MERITON TOWER

9 January 2012

**S.75W MODIFICATION TO MP10_0057 – RESPONSE TO ISSUES
132-138 KILLEATON ST, ST IVES**

SITE SECTION A-A

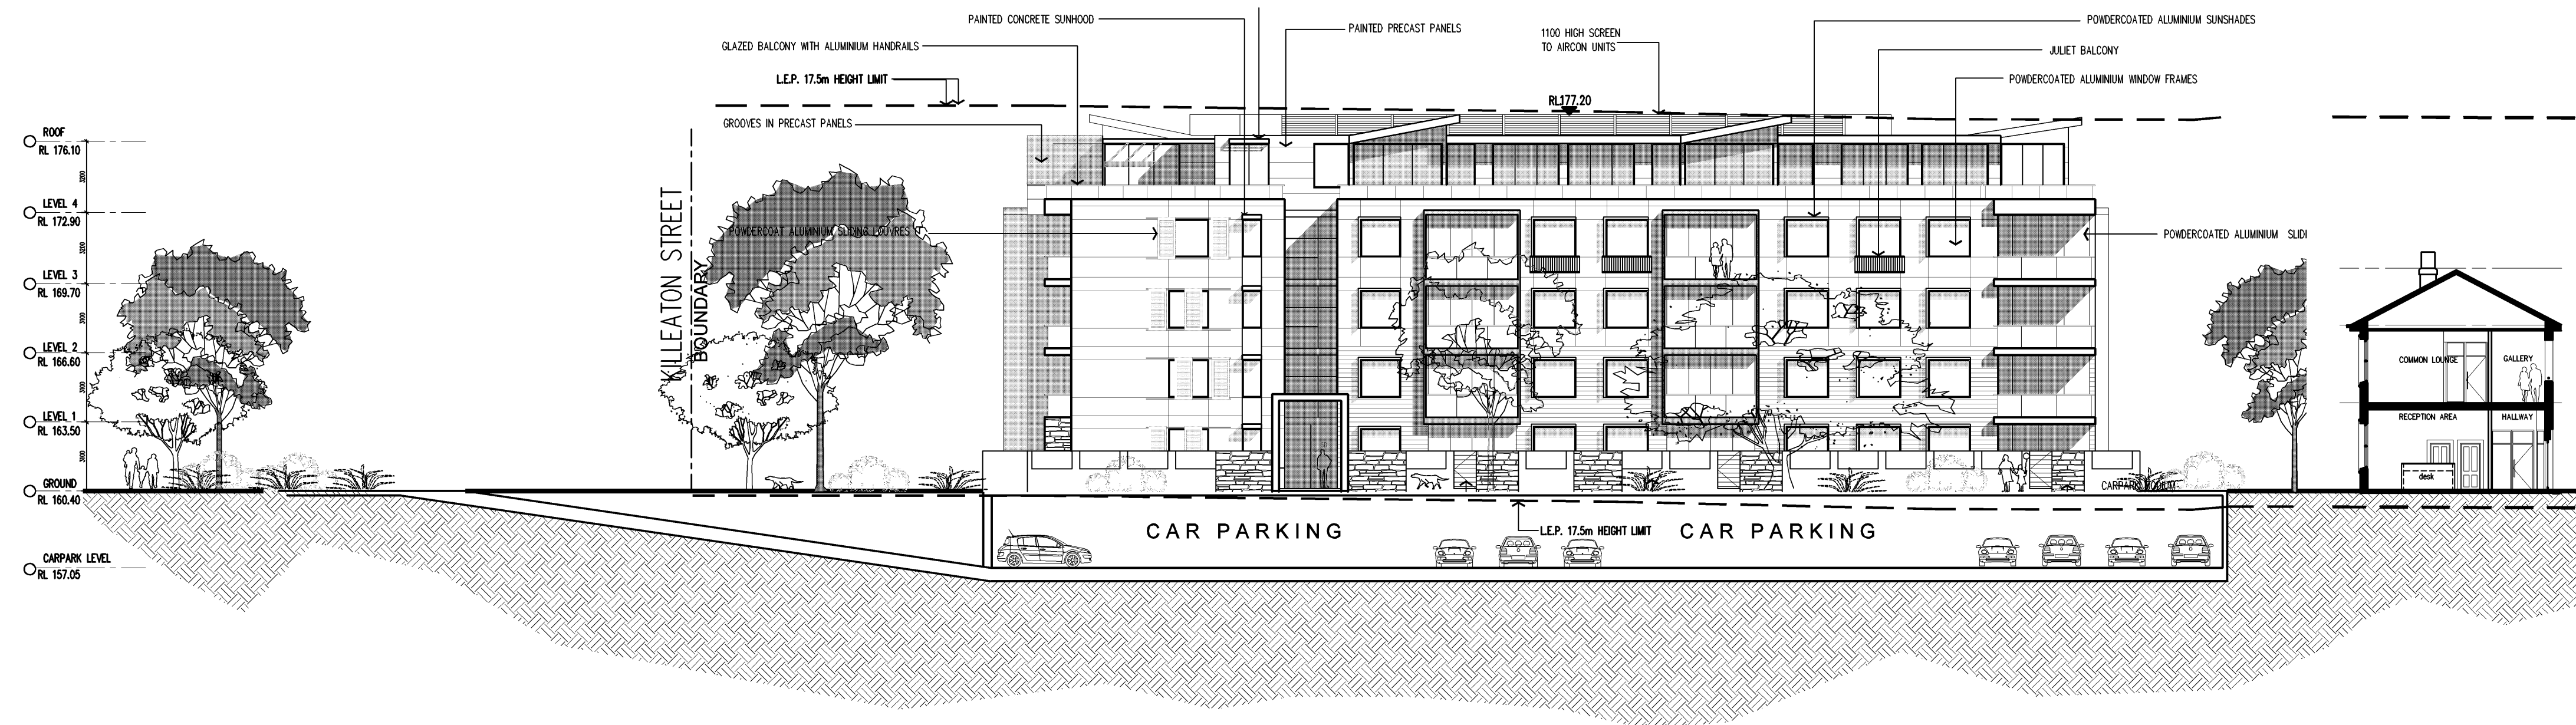
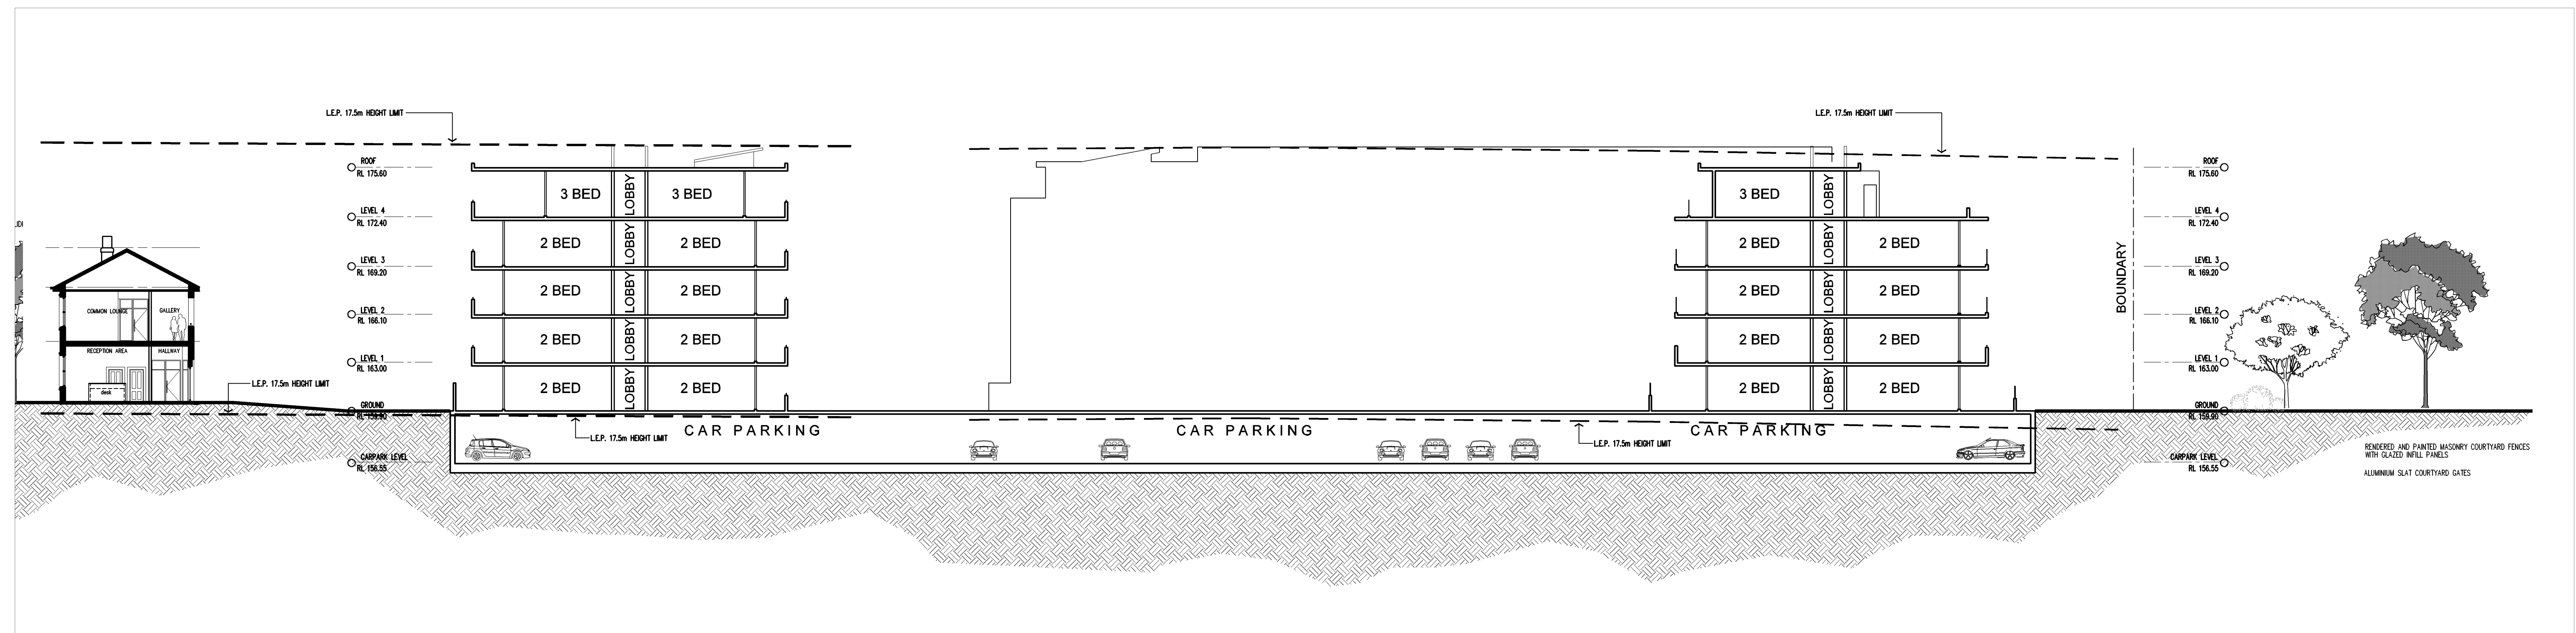
2. Rooftop Water Heaters

It is necessary to construct the rooftop plantrooms at no less than 2.5 metres in height. Enclosed is a letter that has been prepared by our plumbing contractor, K-Mac Hydraulic Plumbing Services, which confirms that a 2.2 metre internal floor to ceiling height is required to install the proposed water tanks. The required 300 mm concrete slab roof to the plantrooms takes the total height requirement to 2.5 metres.
